Engineers Comments Regarding Surface Water Drainage

APPLICATION NO: AL/29/20/PL

Site Address: Tyrone House Norton Lane Norton Aldingbourne PO20 3NH

Description of Works: Demolition of existing house & outbuildings & erection of 1 No. dwelling & detached garage. This application is CIL Liable.

-  Widened entrance to site
-  Proposed new dwelling
-  Proposed new outbuilding (garage)
-  As permitted AL/105/19/HH

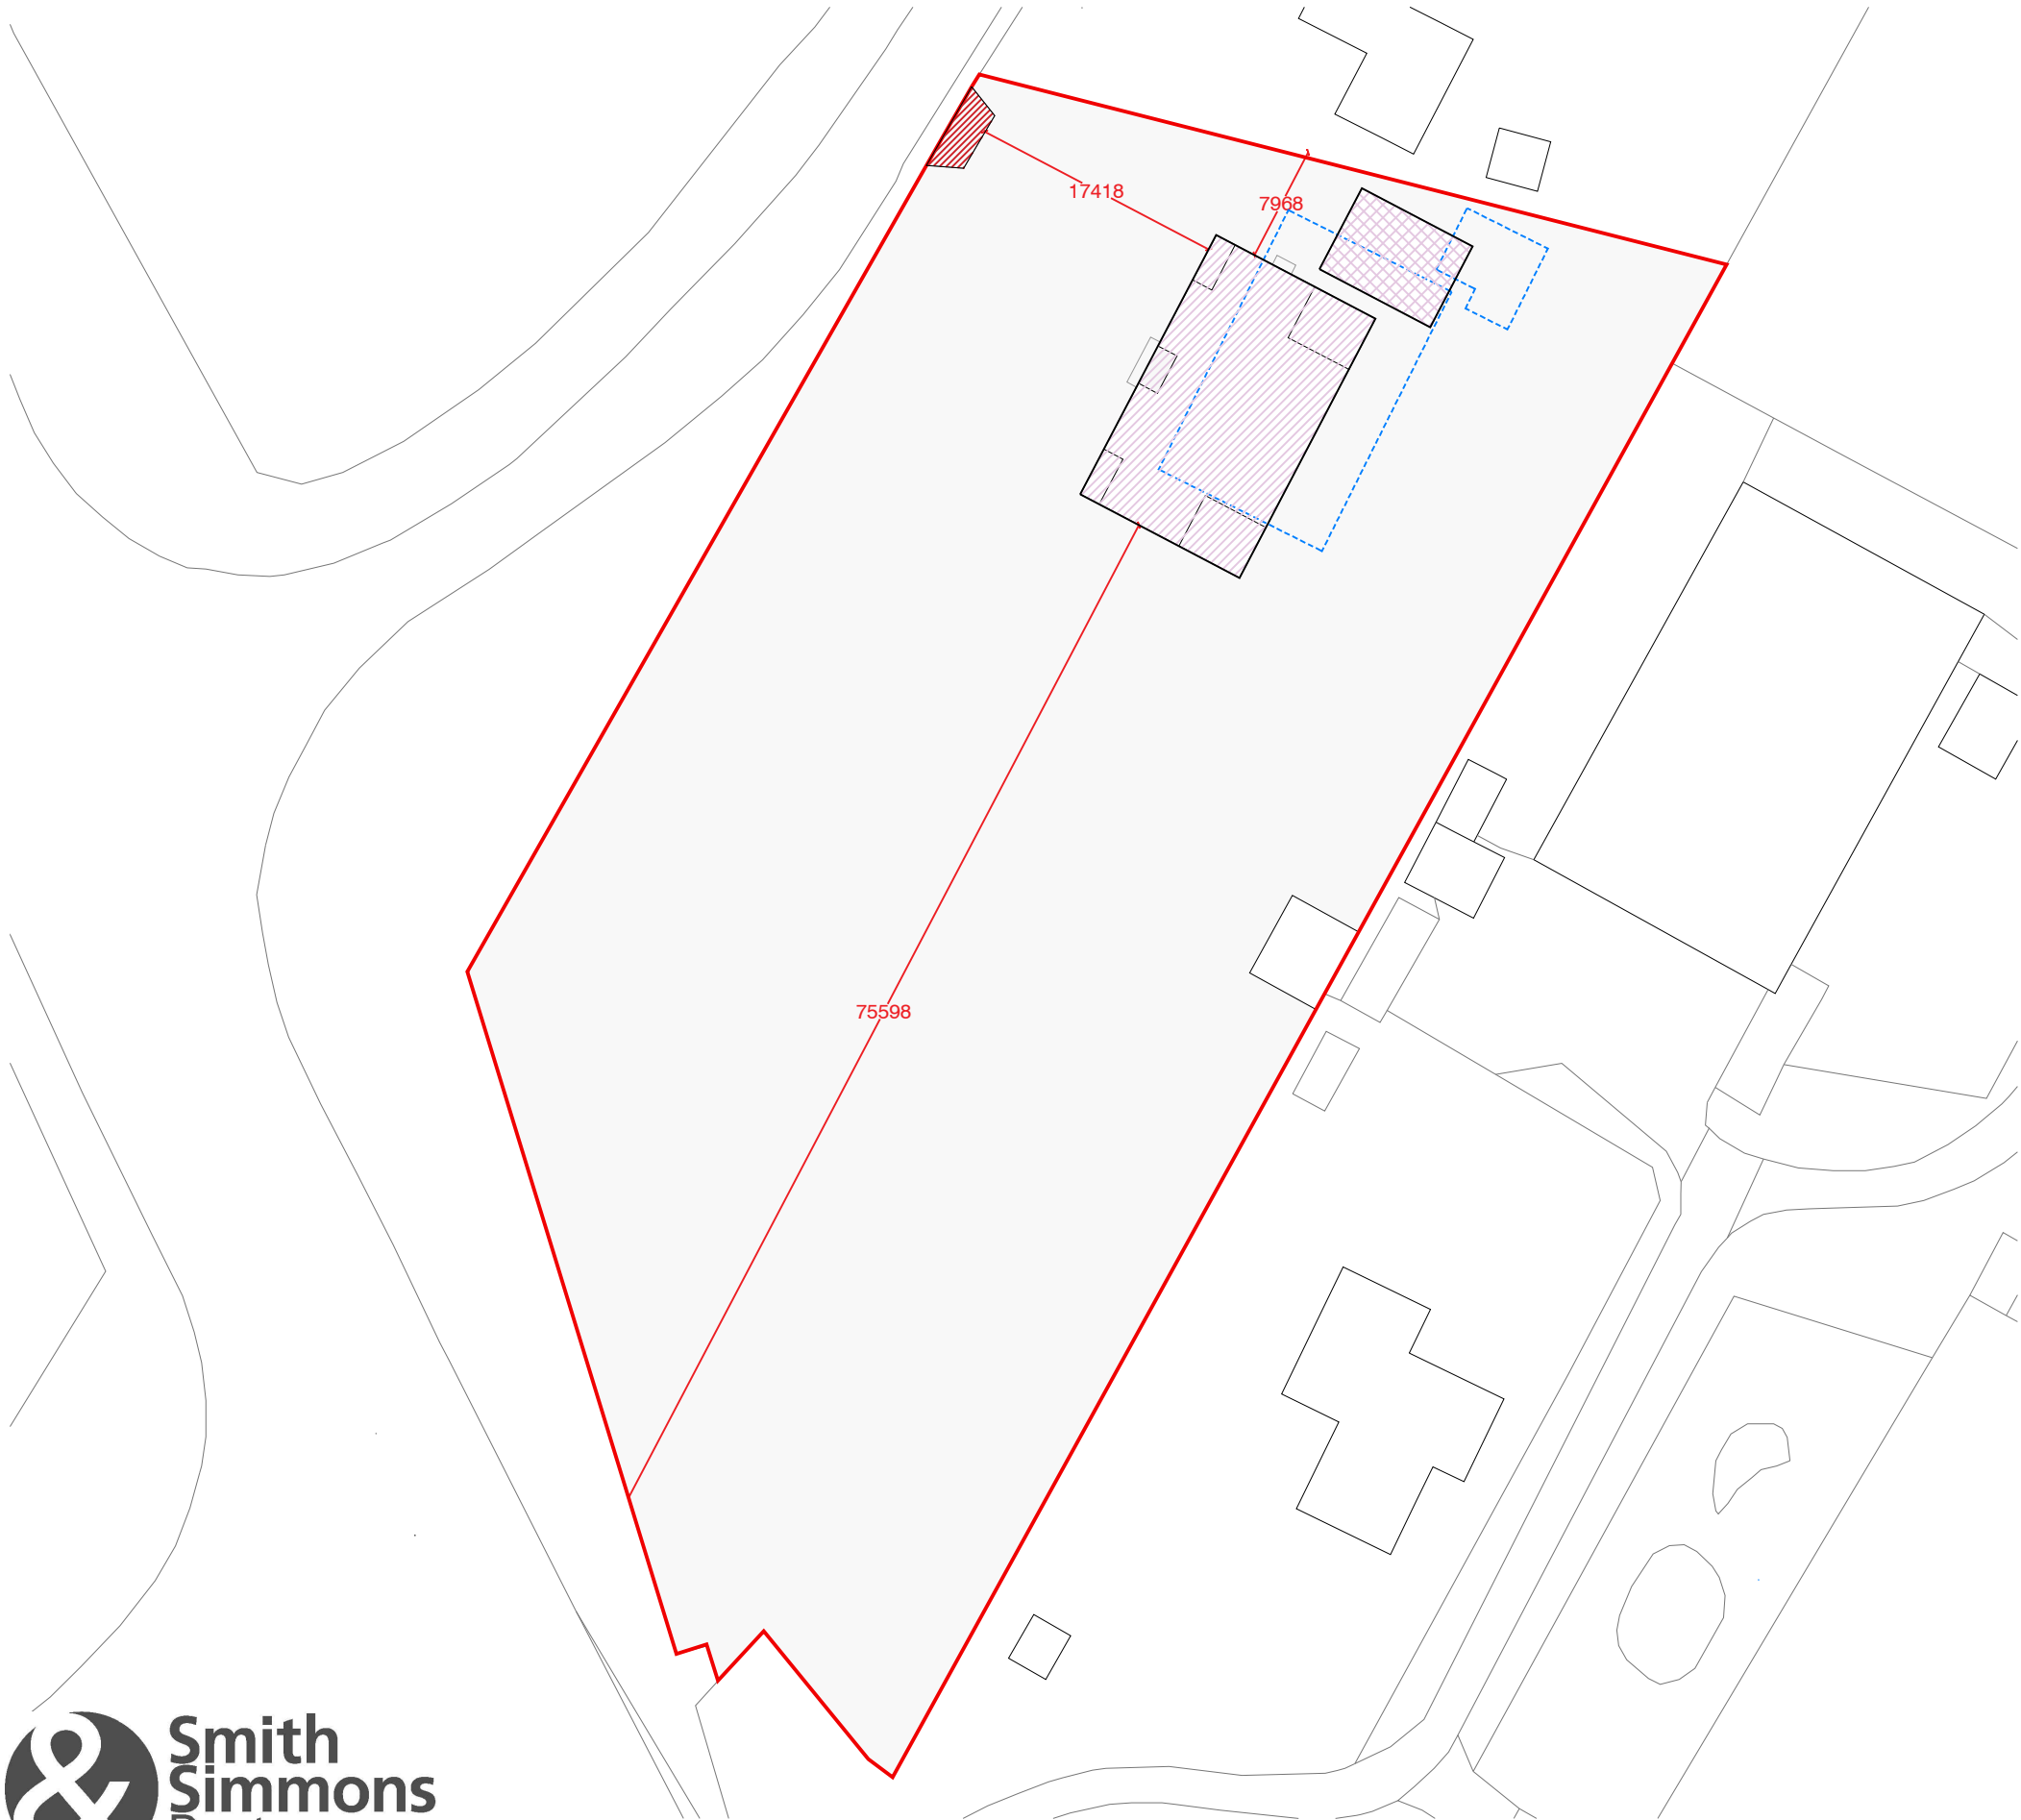
A drainage layout has been provided which shows that the strategy appears to be to attenuate surface water from the roof of the new building in an impermeable lined tank, before discharging at a restricted rate to a ditch on the opposite side of Norton Lane. Surface water from the drive will be allowed to infiltrate at a shallow depth.

At this stage no calculations have been provided to support the design. In addition, the surface water attenuation tank is at a depth below the highest recorded groundwater. Therefore we would expect to see calculations to show that buoyancy has been counteracted (groundwater pushing up the tank). Currently there are no construction detail drawings for any part of the scheme, which we would expect should the application be approved and we were asked to assess the drainage scheme as part of a DOC application.

We would be keen to see any infiltration potential maximised and would like the applicant to consider discharging the roof surface water to the permeable paving via diffuser units (5m from the building) with the option of a restricted overflow to the ditch if necessary. If a connection to the ditch is required then the applicant will need to apply for Land Drainage Consent (from this department) and will require land owner permission to do so (if the land is not owned by the applicant).

Therefore, if you are minded to approve the application please apply a modified version of PCENG2 (as below, to account for work done) to ensure that the applicant provides a robust and sustainable drainage design that can be easily followed by a contractor.

Appendix A – Soakaway Test Location Plan

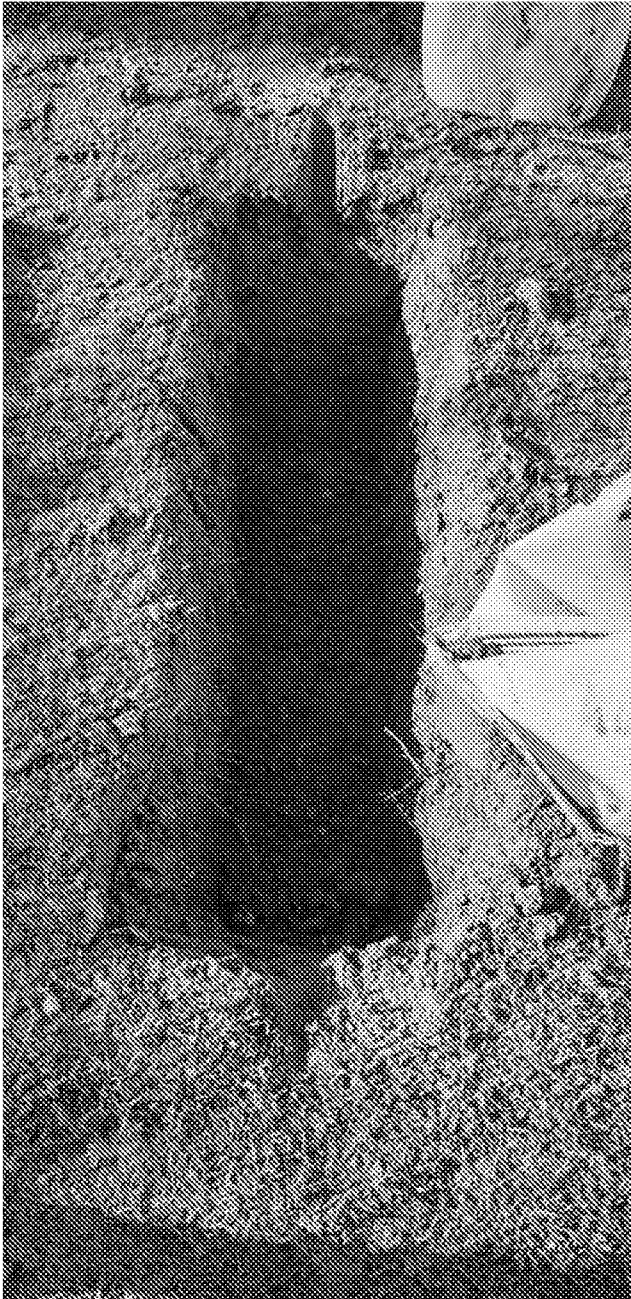
It is noted that the applicant has already considered surface water drainage to an extent. The infiltration testing completed in early March this year is adequate and the presence of groundwater at 0.6mbgl shows that only infiltration at shallow depths will be viable. As such no further infiltration tests or groundwater monitoring are required.
